Development Removal of conservatories & erection of new conservatory & utility room

Location 10 Frobisher Way Rustington

I regret that I am unable to accept your documents as a formal application until the following matters have been resolved :-

Block plan

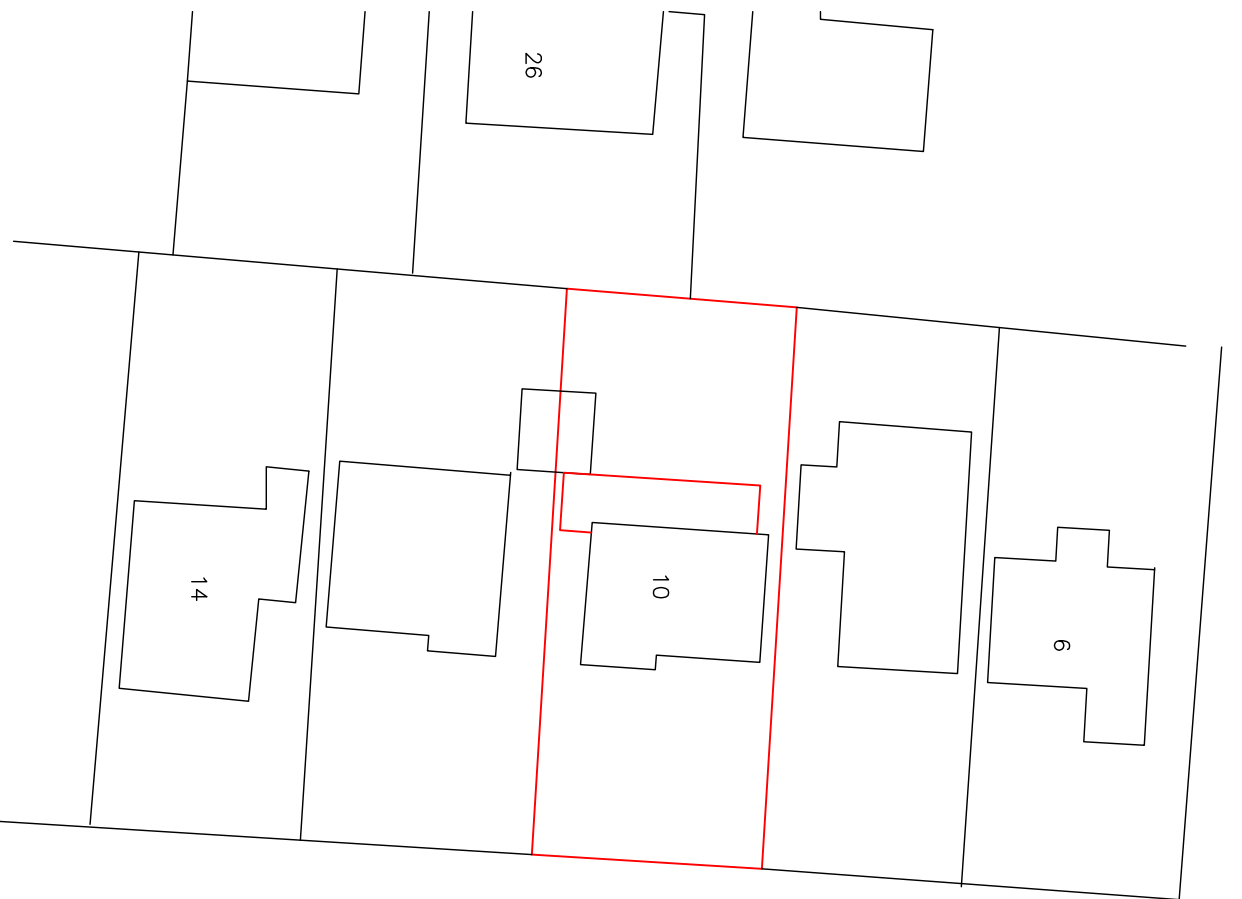
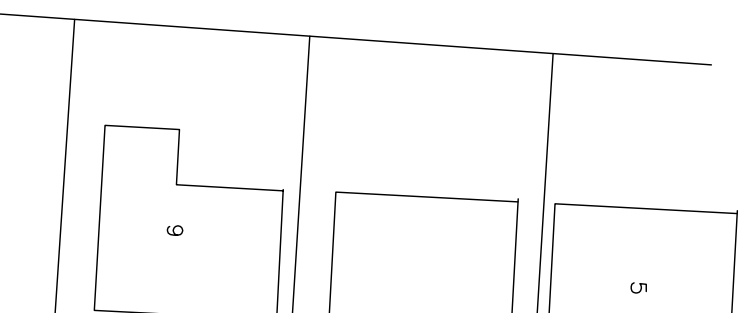
I require 1 electronic or 3 paper copies of a revised block/site plan to show the position of the existing conservatories marked as a dotted line.

Drawing:
Plans and elevations as existing

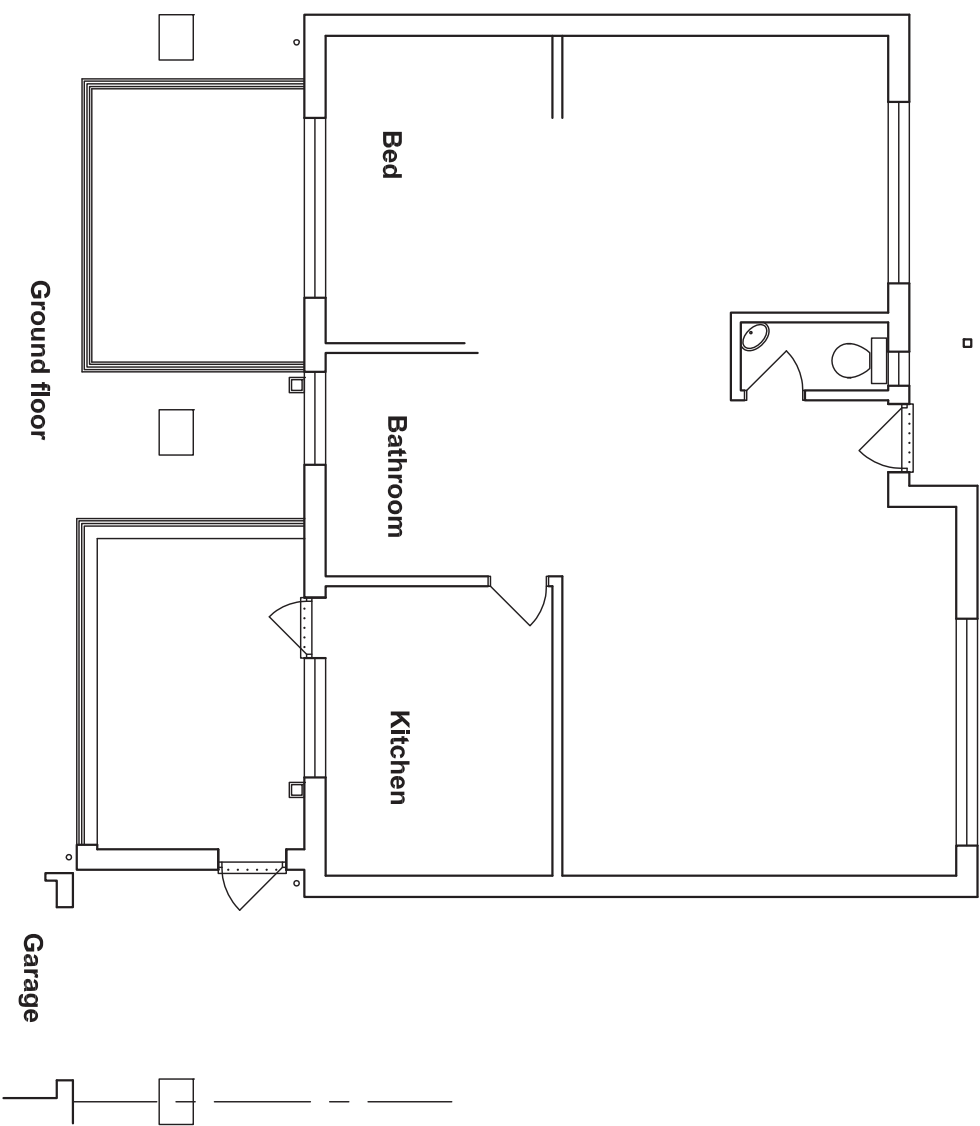
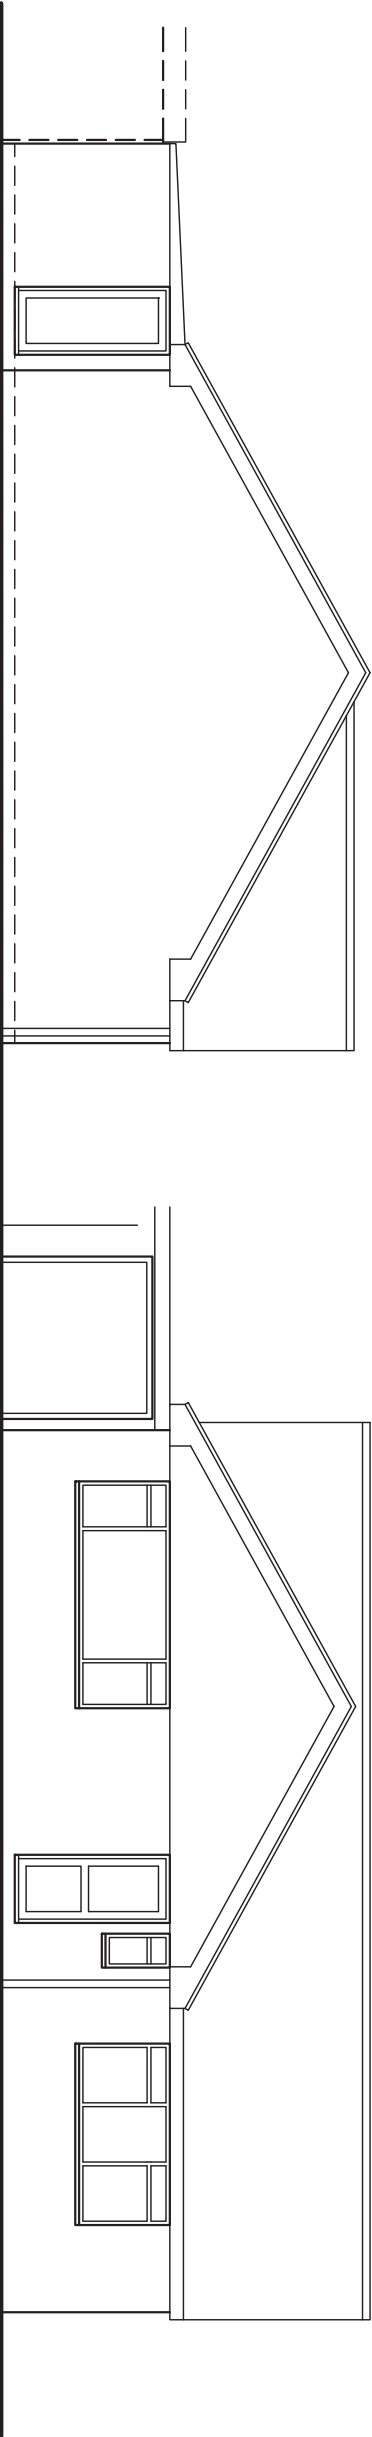
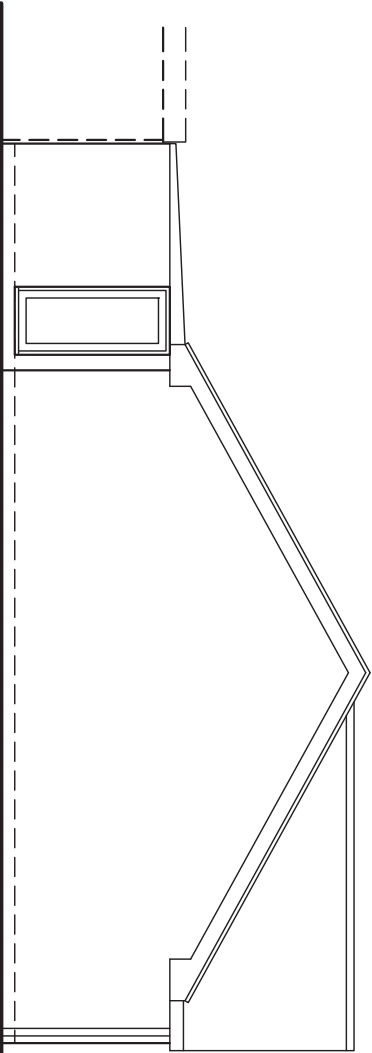
Please provide 1 electronic or 3 paper copies of revised existing and proposed floor plans to include front section of the dwelling.
